Mr. Gasawski,

I am writing in response to the recent County approval of the SEPA for the proposed Easton Travel Center. I have reviewed the SEPA documents and have a variety of "common sense" concerns as part of the public comment process.

**PRELIMINARY SITE PLAN**  
 MOUNTVIEW GROUP LLC TRAVEL CENTER  
 WEST SPARKS ROAD  
 EASTON, WASHINGTON

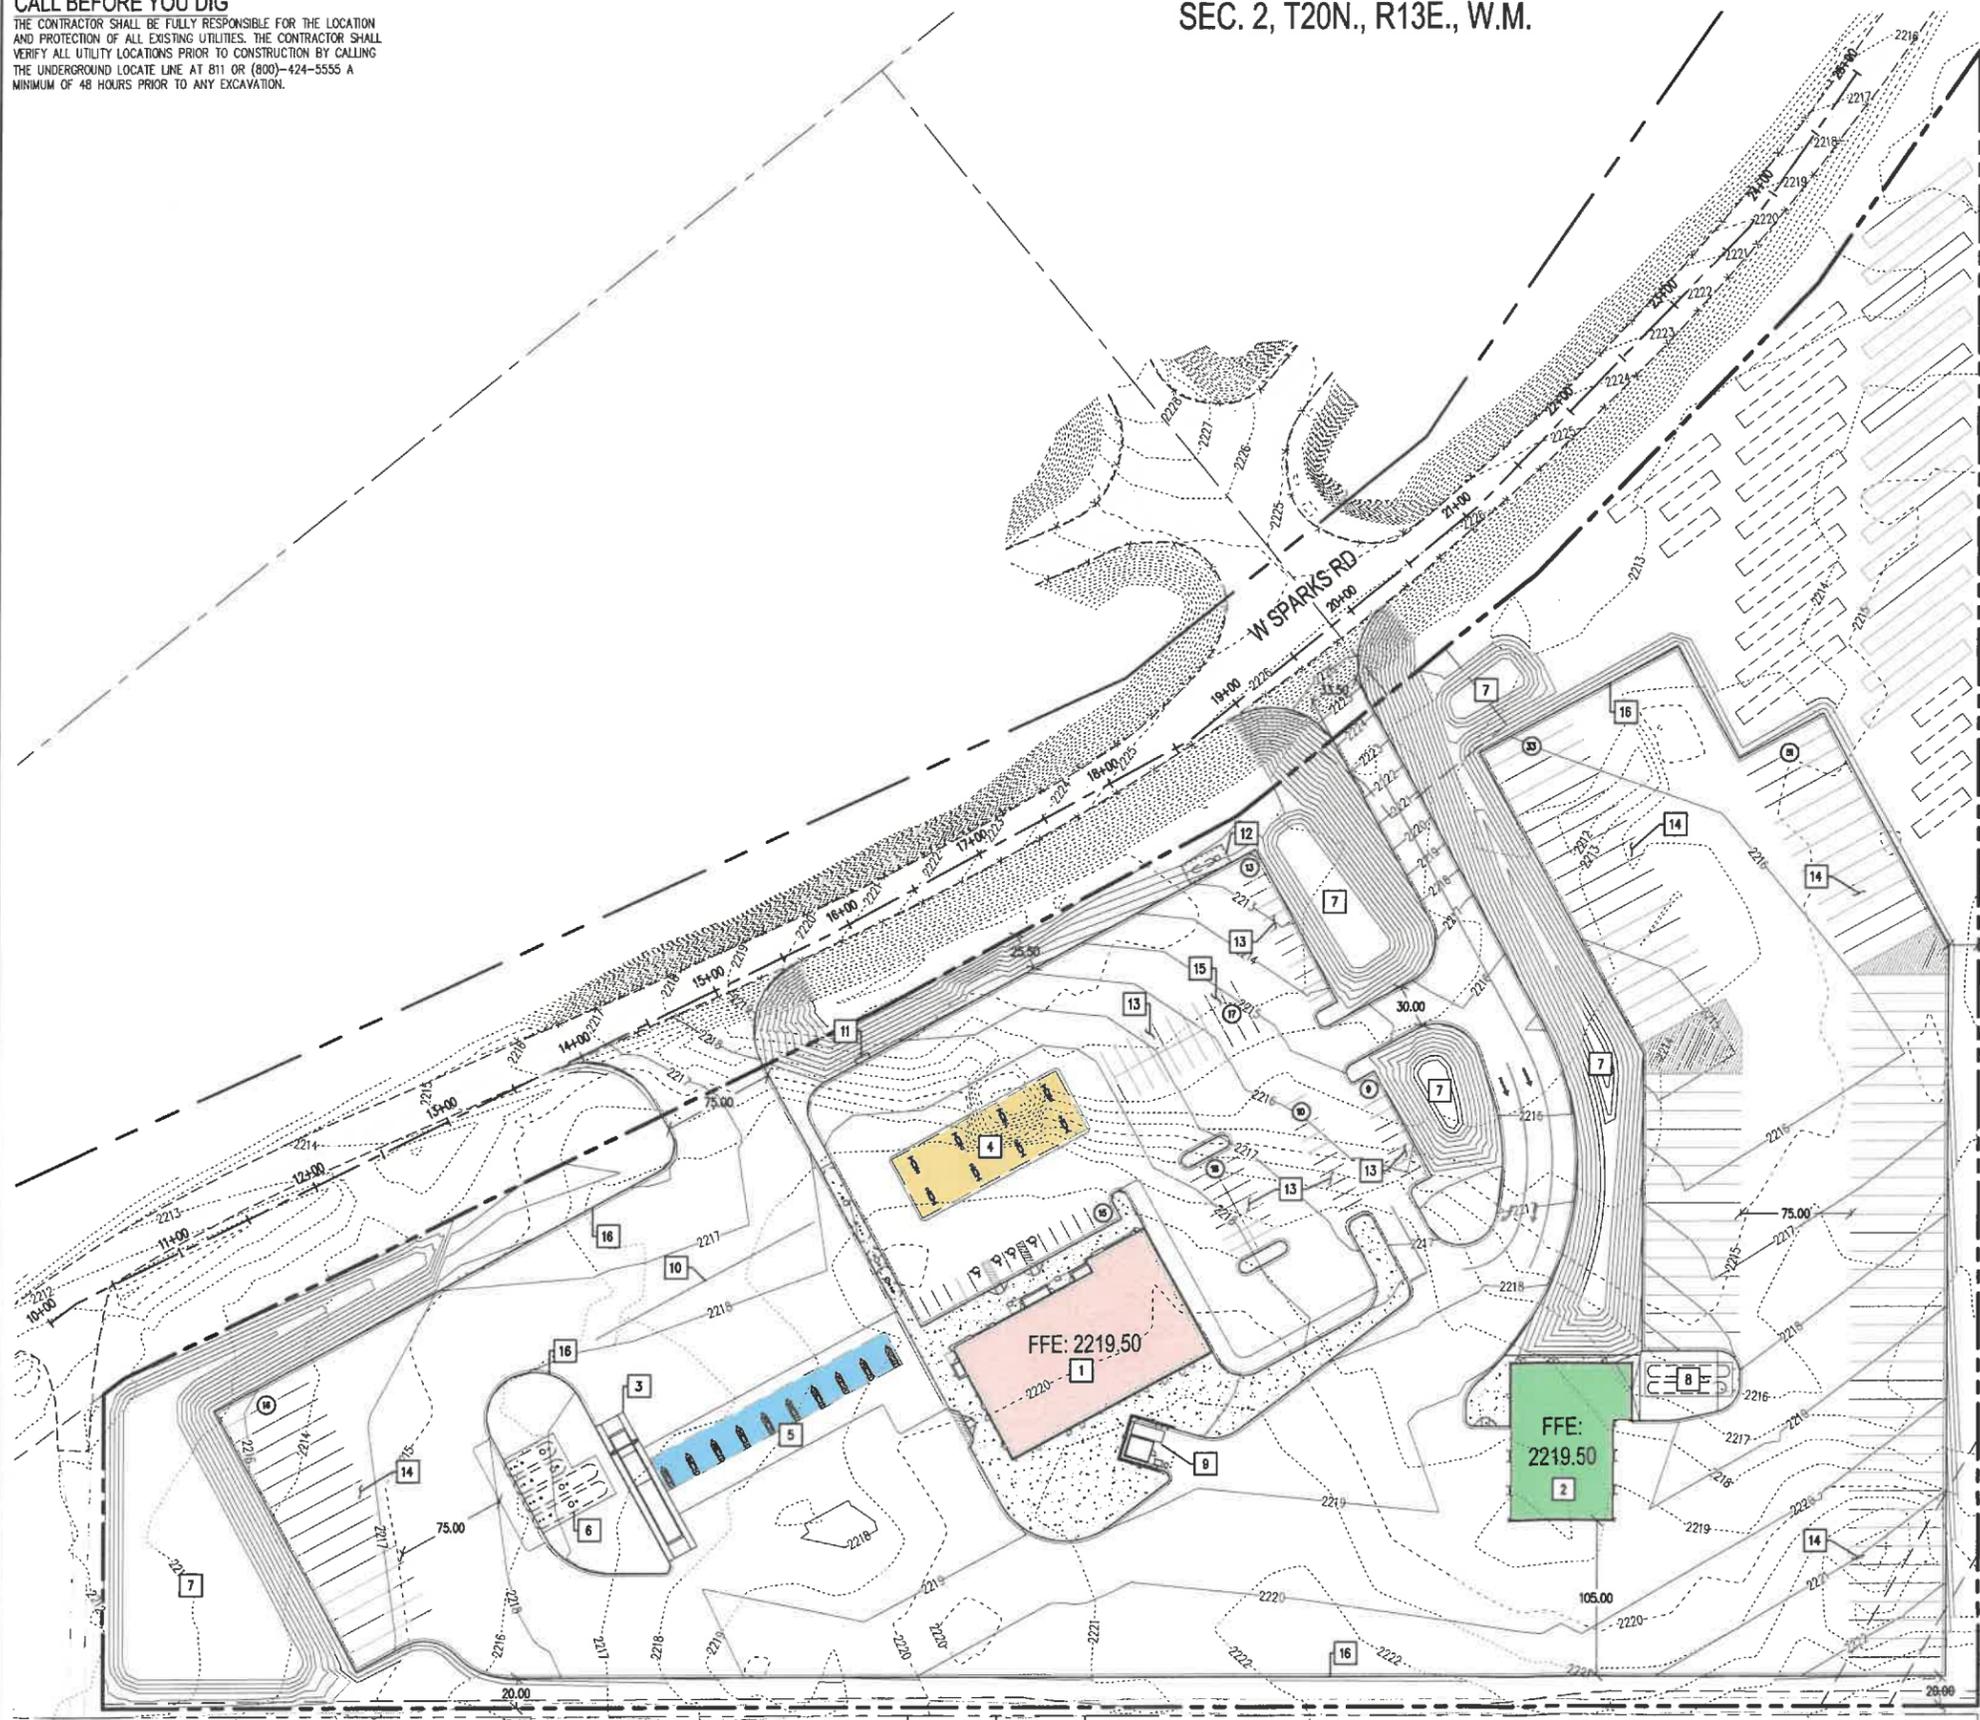
Regarding snow, I was unable to find any reference to a detailed snow removal and storage plan. Facilities of this type will be removing snow contaminated with petroleum-based products, or worse, hazardous products from leaking trucks and cargo containers. If the snow is not treated as runoff and stored on impervious surfaces with proper best management practices, the potential for groundwater contamination is greatly increased. I fail to see where adequate storage exists on the site plan.
